SDNP/21/06400/ADJAUT

Neighbouring Authority Consultation

Proposal: Adjoining Authority Consultation - Approval of details reserved by condition imposed under A/40/18/OUT relating to condition 5-Design Code Master Plan.

Address: Land North of Water Lane Angmering

Figure HBA 2: Copy of updated Land Use Parameter Plan (drawing 19271 rev C01) by OSP

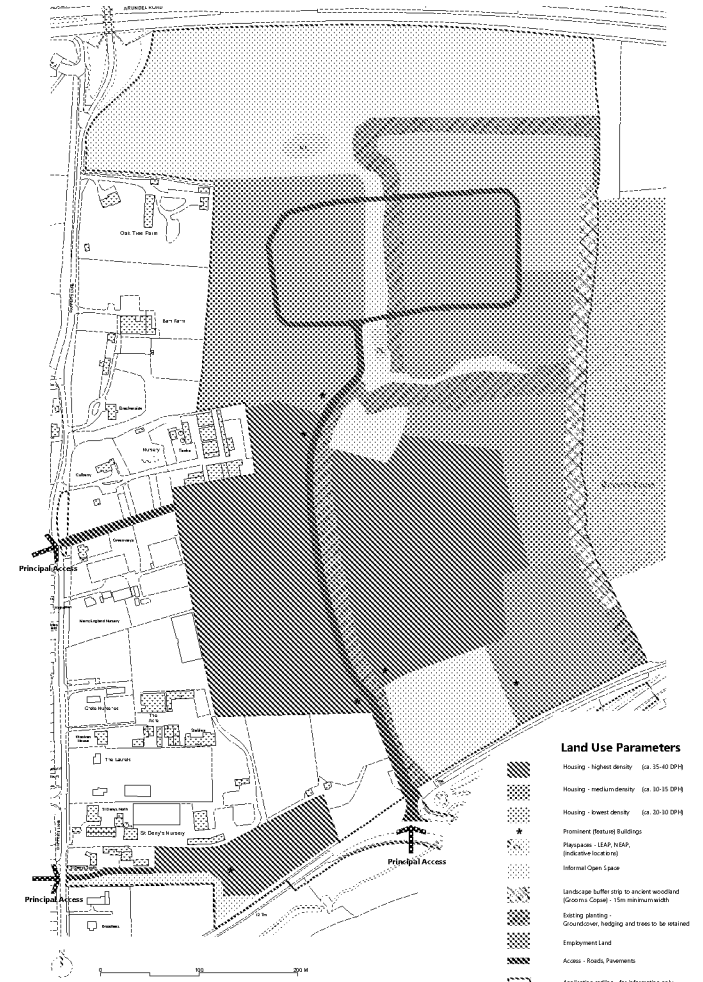
Of greatest significance to the National Park is the extension of the amended layout to the higher ground to the north, into the landscape buffer/public open space. This will affect in particular the views from the SDNP to the south-east, looking across the site and back into the National Park, where this northern field is clearly visible and contributes to the rural character. We note that the overall ridge heights AOD are not intended to change, but this does not necessarily address the noticeable urban expansion further into the northern parts of the site and away from the historic settlement core of Angmering in such views, albeit that the general principle of lower density housing to provide more of a rural edge to the site is welcomed. The SDNPA therefore considers it would be essential for the LPA to secure visualisations in order to properly understand the impacts. These would also help understand the impacts of some of the larger, more bulky (approaching 3 storey) flats to the southern end of the site, as well as the effectiveness of proposed tree planting throughout the site.
